From: Simon Davis
Sent: 29 November 2017 12:52
To: 'Phil Brown'
Subject: BE/79/17/PL

My report has been written and has now been reviewed by my Team Leader. However, before we can issue a decision, we need a couple of things resolving:

SITE LOCATION PLAN 1:2500

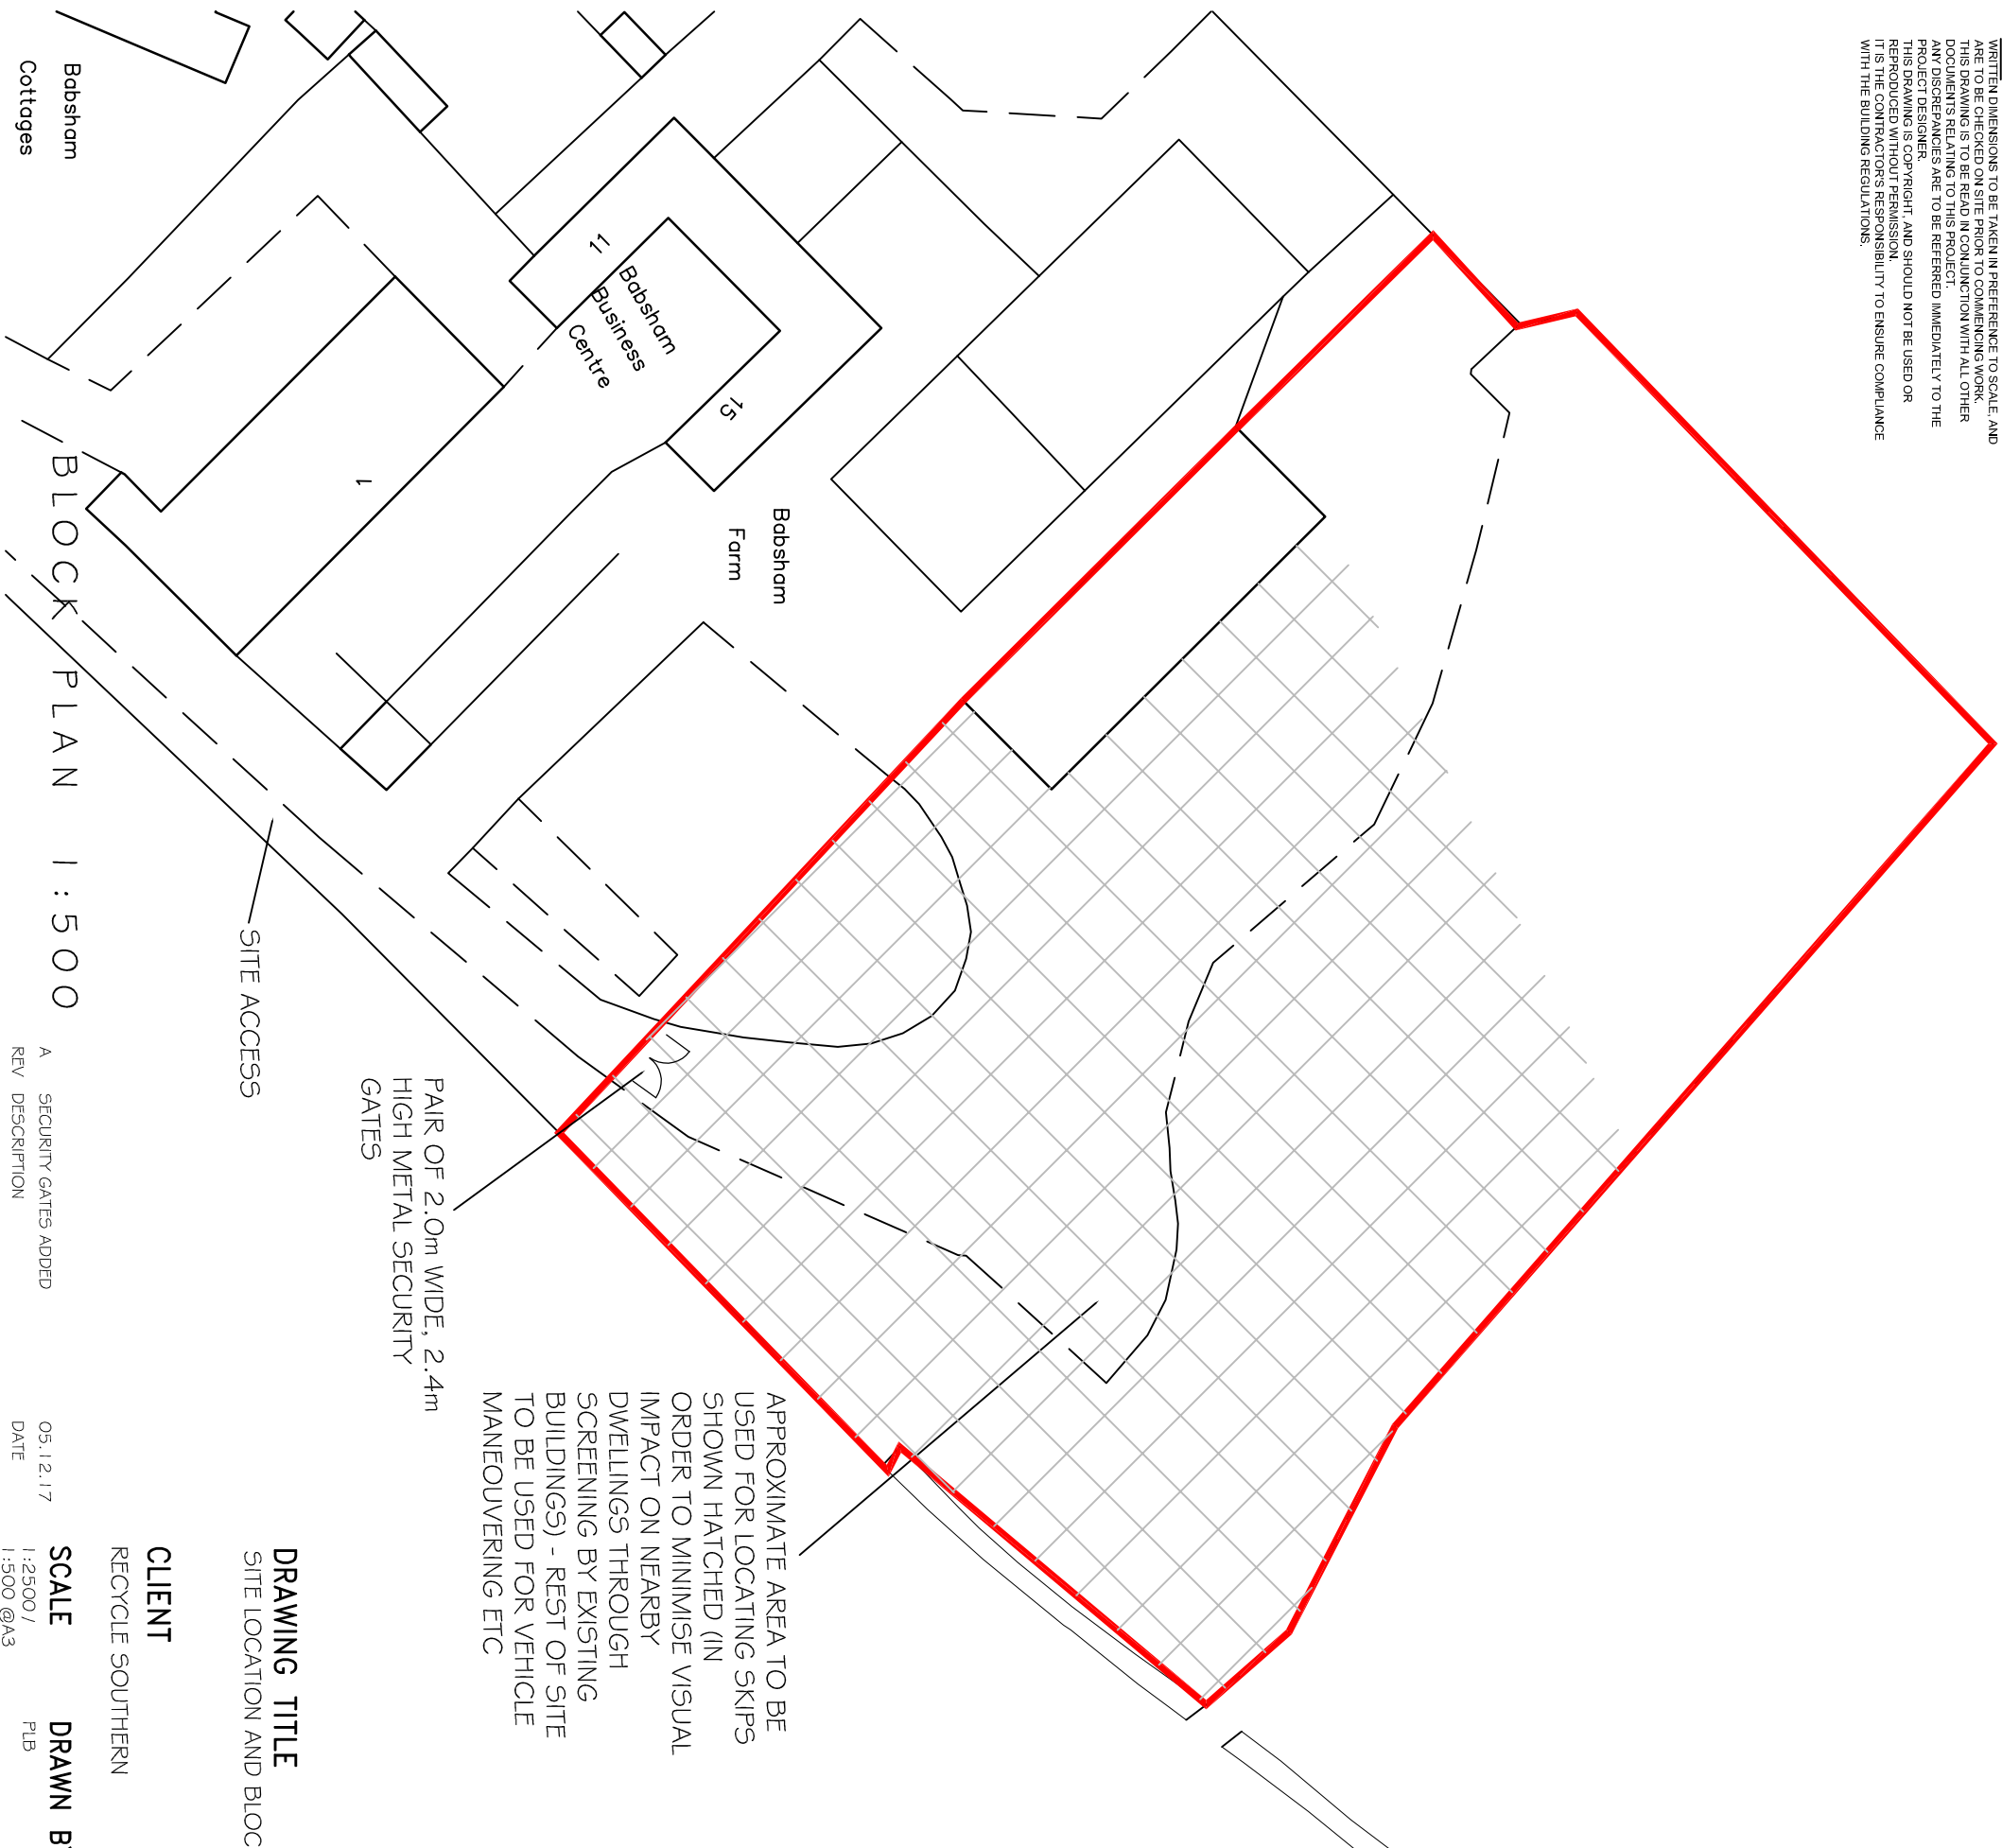
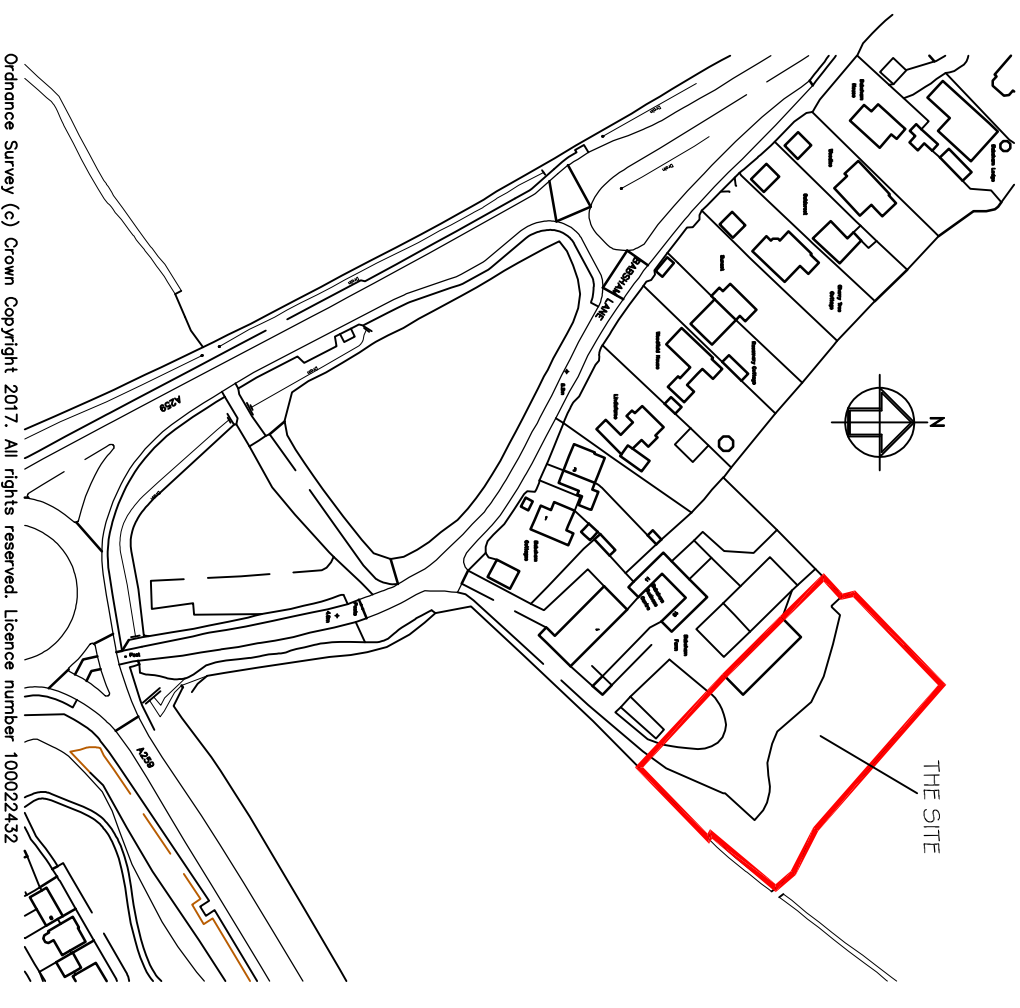
- (1) You mentioned in follow-up emails that a security gate was going to be erected. I was proposing to require the detail of this to be approved by condition. However, the condition could be avoided if you give us details (location on the plan + elevations) now? Please note that if the height of the gate were to be significantly greater than 2m, we would likely need to re-advertise the application to local residents. Likewise, if a gate significantly higher than 2m were proposed to discharge a condition, we might not be able to agree it.
